Expert Review of “Munmorah Power Station Rehabilitation Project Review of Elevated Sulfur Dioxide Emissions” Report

Final Report for Aurecon Australia Pty. Ltd.

19 February 2010

Figure 8: Modelled concentration profile on the 28th January 2004

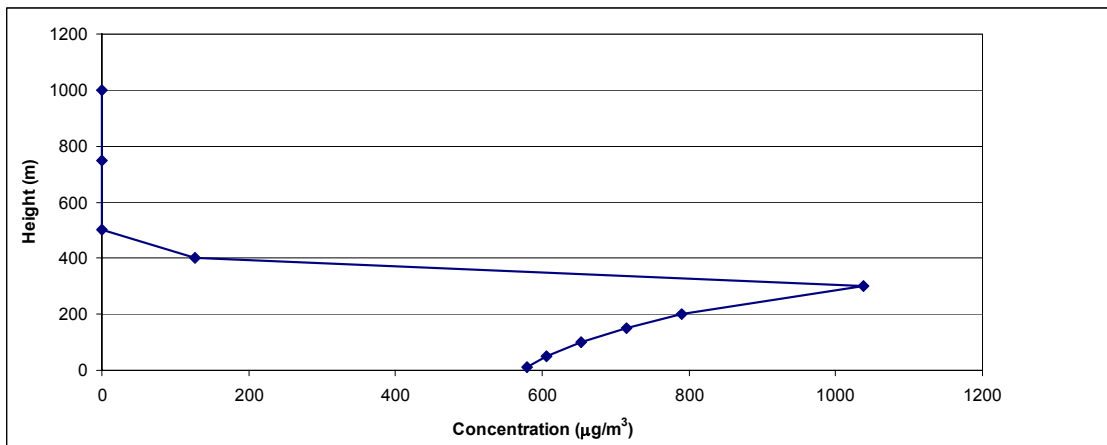
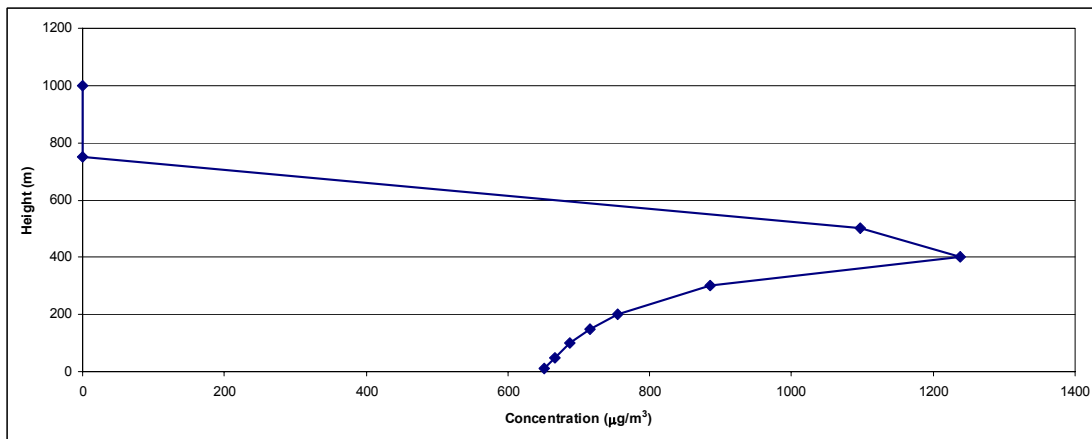
I think that the author wants to make the point here that because the Munmorah plume is not a particularly buoyant plume, its final-rise height is moderately low (300m on 28 January and 400m on 31 March according to TAPM in Figs. 8 and 15) and this leads to a higher concentration when fumigated than if it was more buoyant and levelled out at a higher elevation. However the author seems to be arguing that it is low-mixing heights that lead to high glcs, whereas it is plume height, not mixing height that is the relevant factor. It just needs a bit of re-wording. Even if the mixing height in reality reached 600m by midday, this just means that the fumigation occurred earlier, when the mixing height reached 300m and 400m respectively for the two days, with the same glc result, all other things being equal.
